Application No: BR/5/26/PL
Site Address: 35 Glamis Street Bognor Regis PO21 1DJ
Description of works: New build 2 storey residential townhouse comprising of 1 No 2b/3p and 1 No 3b/5p flats. This application is in CIL Zone 4 (Zero Rated) as other development.

OBJECTION

PROPOSED VIEW ON GLAMIS STREET

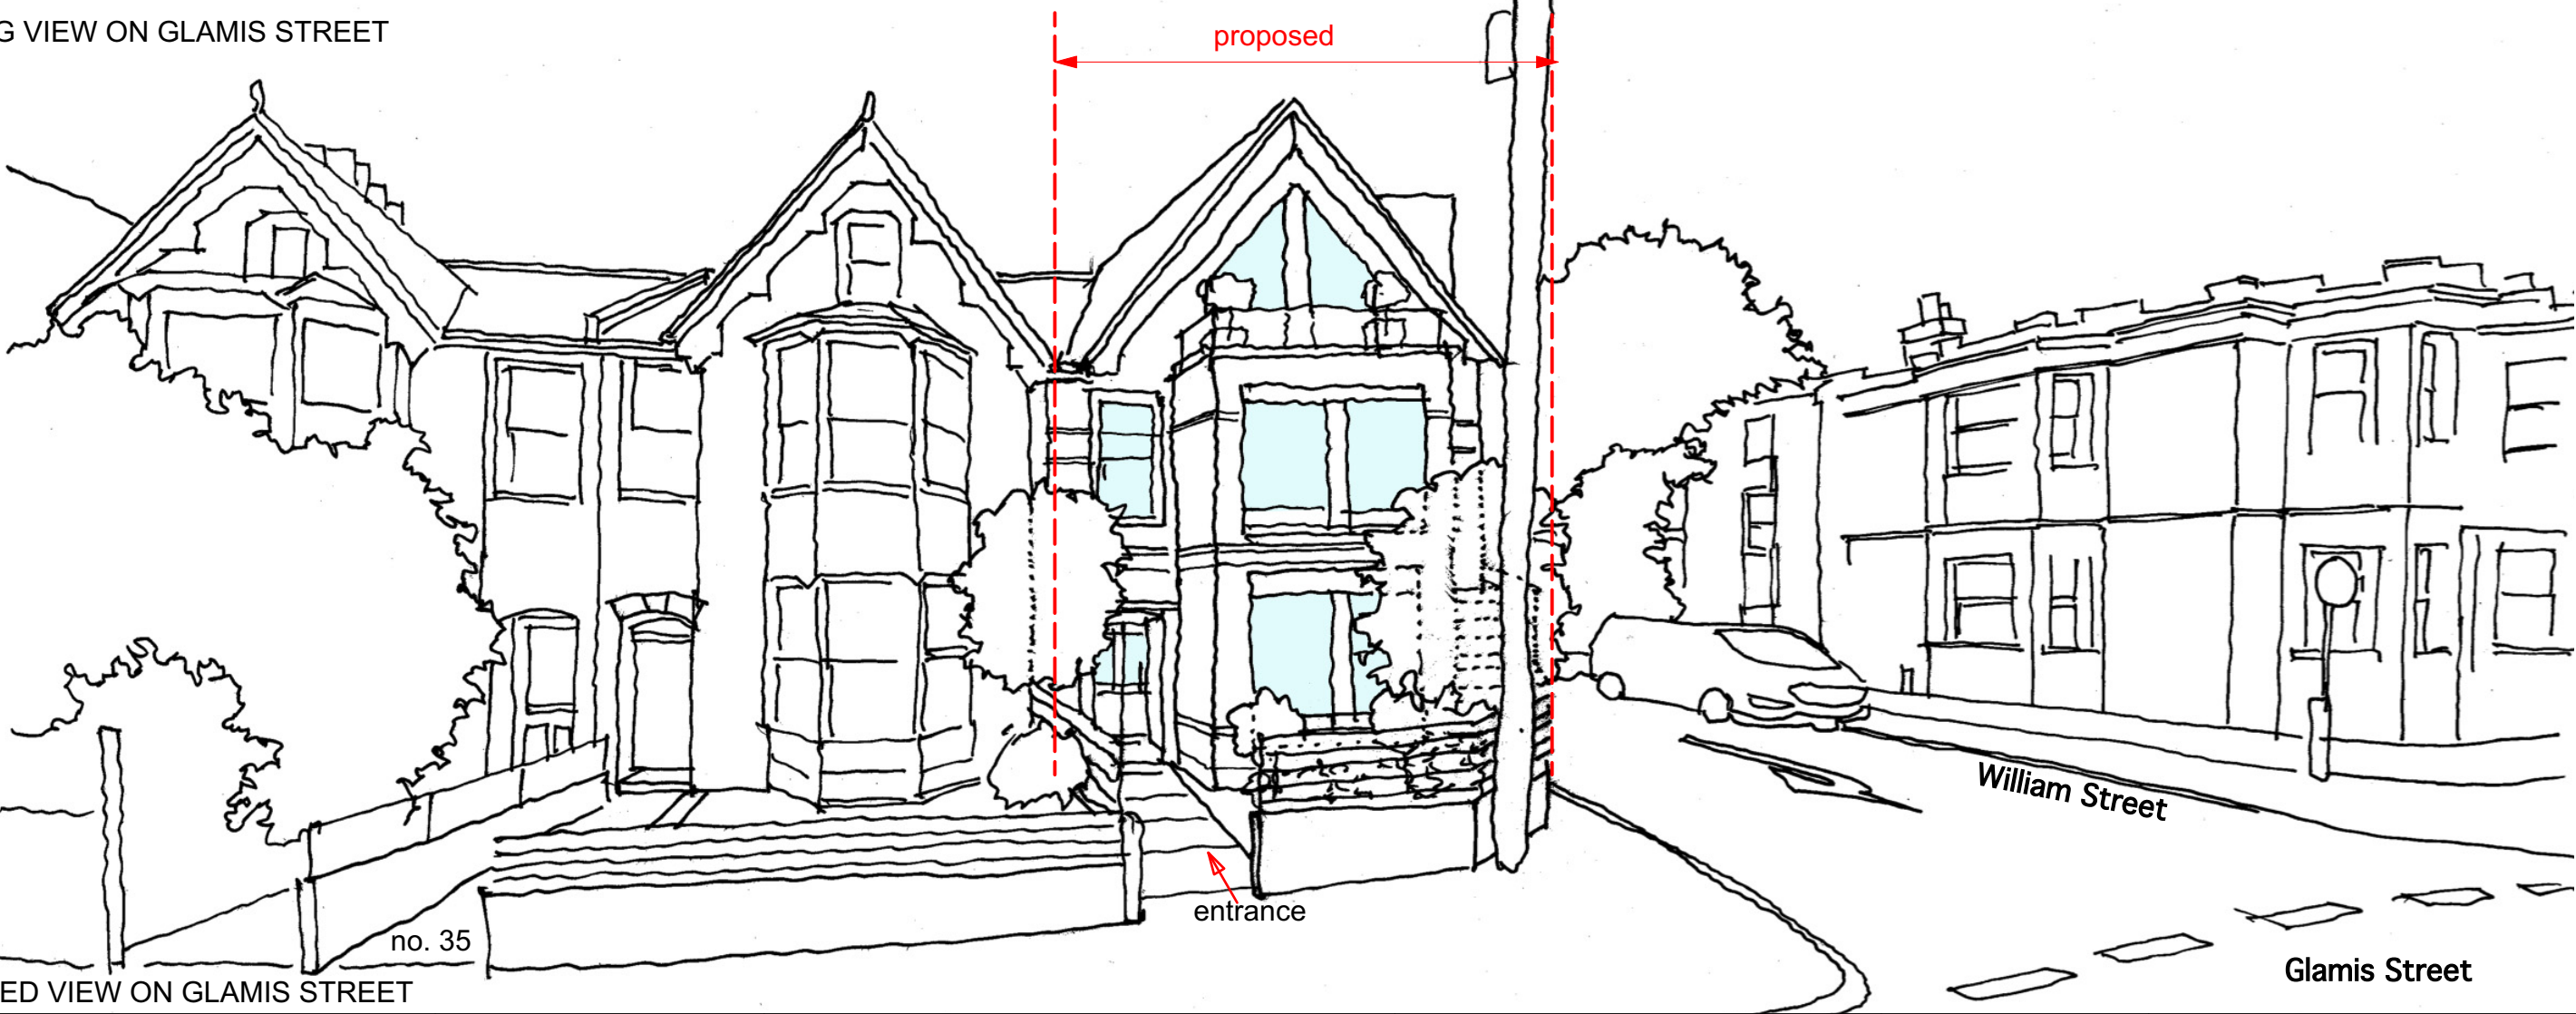
Harm to Character of the Area (Arun Local Plan Policy D SP1; NPPF Para 130)
The proposed development would appear incongruous within the established street scene, resulting in harm to the character and appearance of the area, contrary to Policy D SP1 and paragraph 130 of the NPPF.
